CITY OF MERCER ISLAND
Community Planning & Development

Ref: Intake Screen 2006-158
Site Address: 8802 SE 37th St Mercer Island

REVIEWERS COMMENT RESPONSE LETTER

A. Average Building Elevation (ABE) calculations located on sheet #:
 B. Allowable Building Height (ABE + 30 ft.)
 C. Proposed Building Height
 D. Benchmark Elevation*
 E. Describe Benchmark Location (must be undisturbed throughout project)

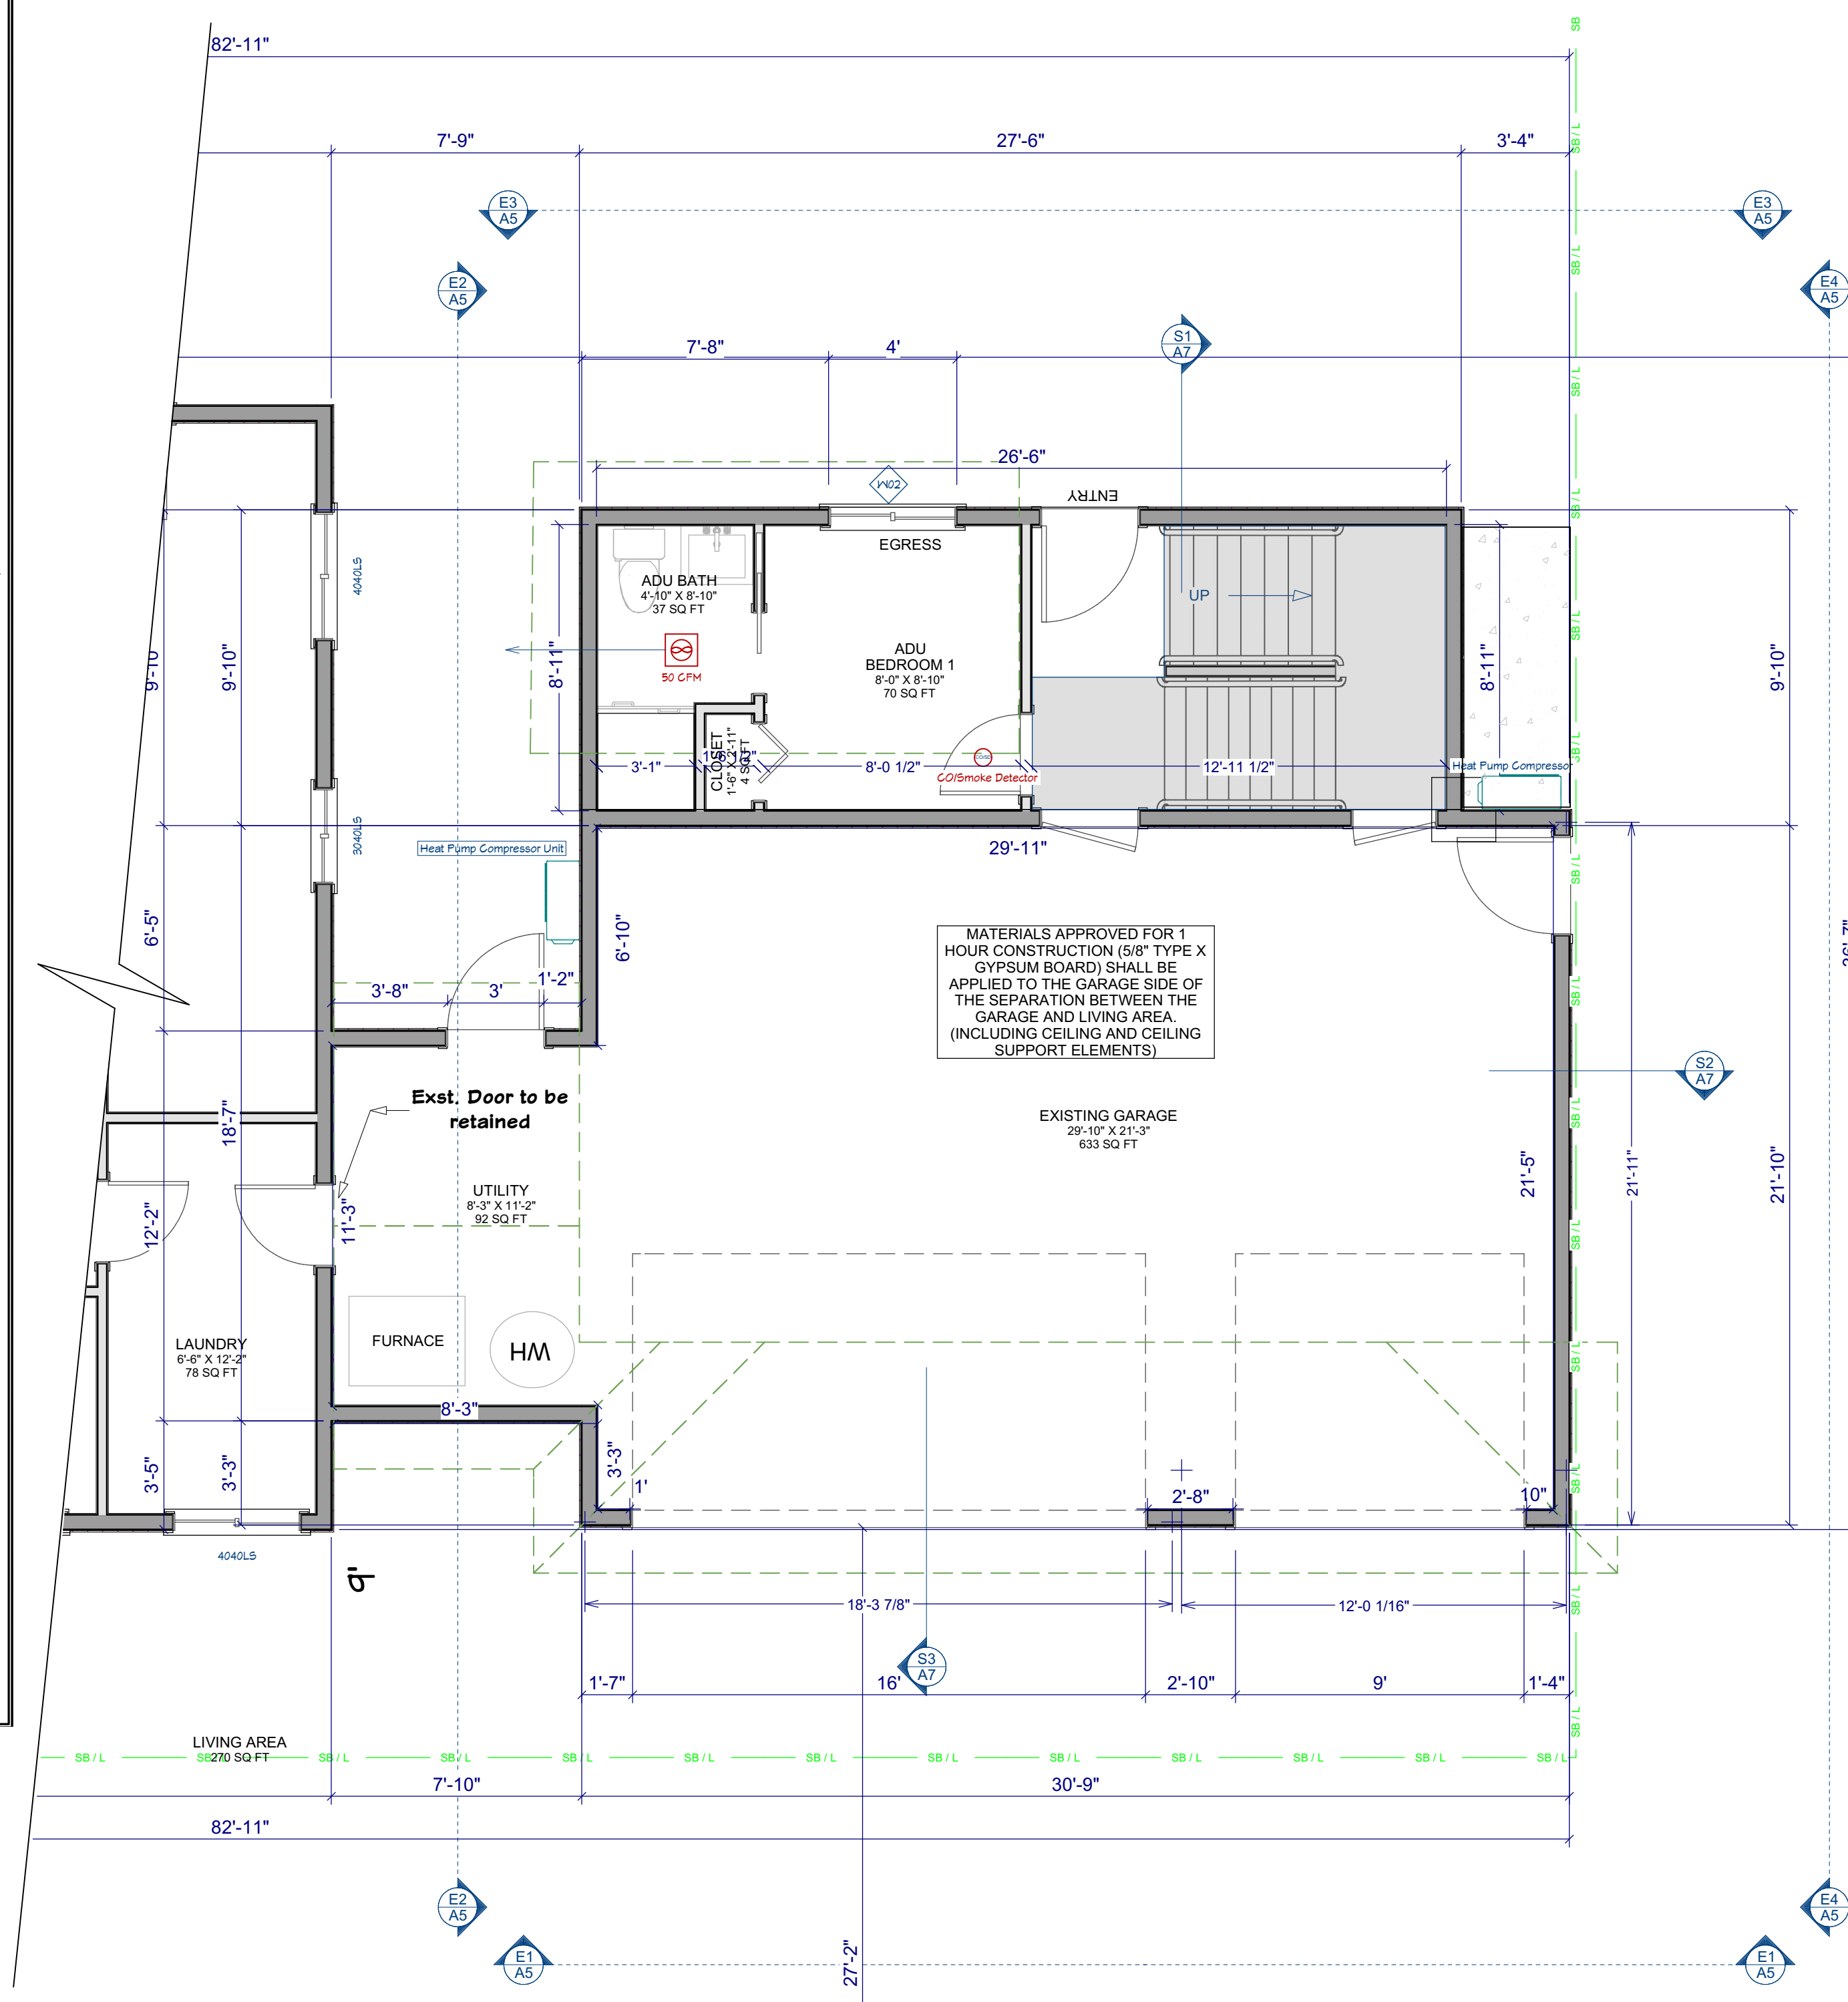
Building Division; Garth Reech.

Compliance path used is 2018 IRC. The design considers $K_{zt}=1.6$ per Mercer Island Mapping. New supplemental sheet P.2 provides Braced Wall Calculations based on this consideration. Headers are also based on 2018 IRC Table R802.5.1(3) Sheet A9 .
GLB gravity calculations provide on sheet SP.2
